Our ref: WA/2022/129968/01-L01

Date: 10 November 2022

Proposed Village Parking Area For 8 Vehicles To Relieve On-Street Parking Issues, With New Footbridge Over Stream And Footpath Formed Along Wroxton Lane

Land South Of The Old Council Houses Opposite Brook Cottage, Wroxton Lane, Horley, OX15 6BB

DRAWING No. 2138 - PL - 04

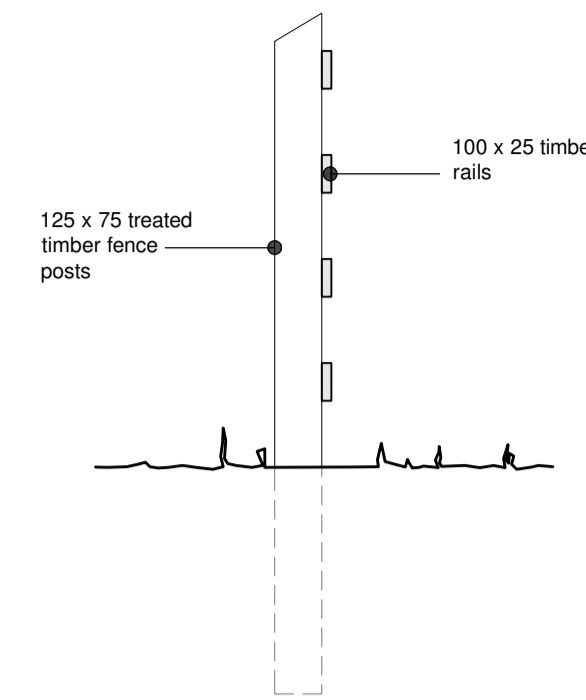
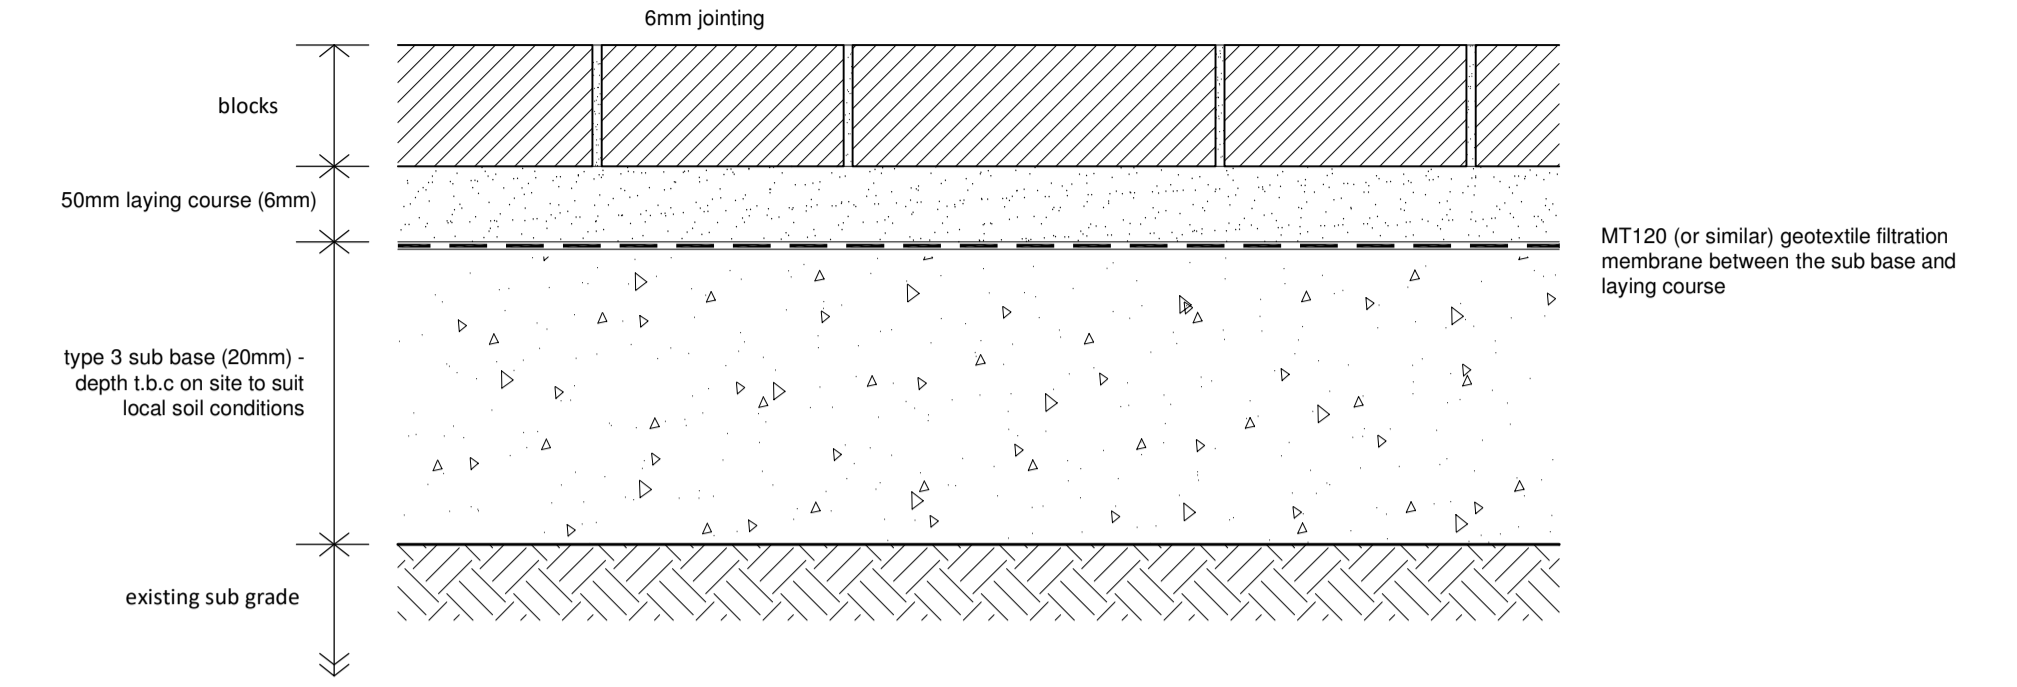
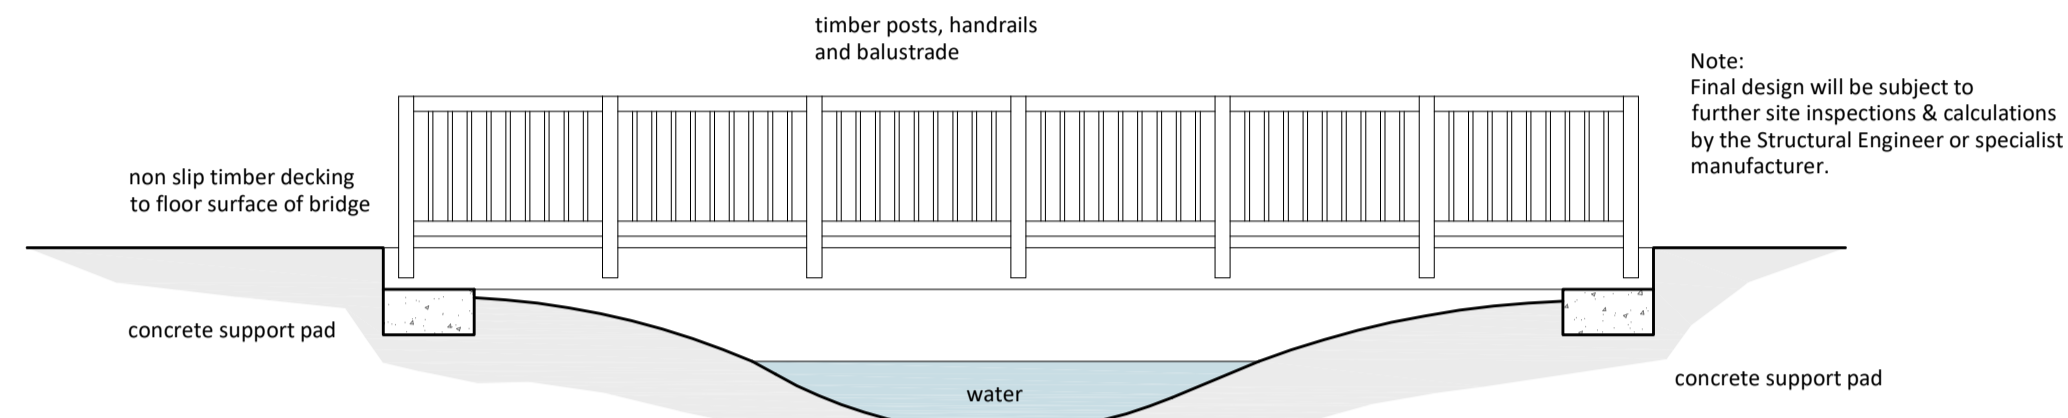
- Details of how the proposed clear-span footbridge will be sited over the watercourse to include the setting back of abutments from the bank top by at least 1 metre
